Town & Country Planning Act 1990 (as amended)
Town & Country Planning (Tree Preservation) (England) Regulations 2012
Application for Works to Tree(s) on trees subject to a Tree Preservation Order (TPO)

Development Remove branches overhanging neighbouring garage to a maximum of 2m 1 No. Evergreen Holm Oak tree.

Location 110 Barrack Lane Aldwick

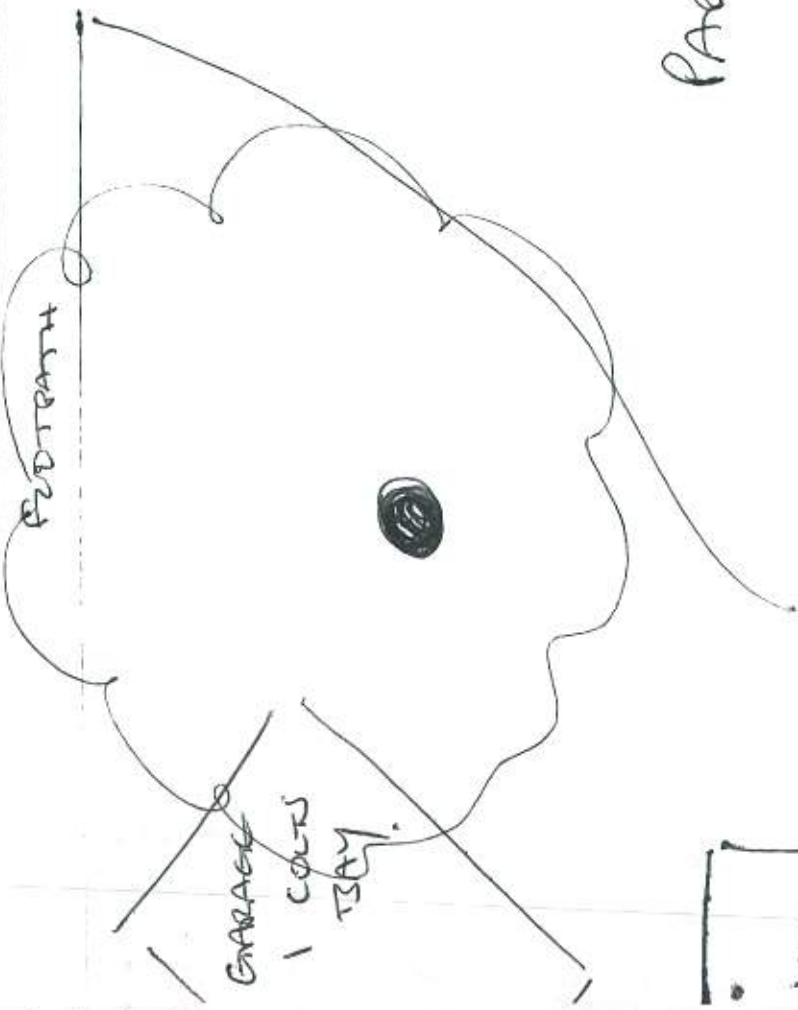
Please clarify if the branches are to be removed by a maximum of 2m, or if 2m is to be the length of branches after the proposed works.
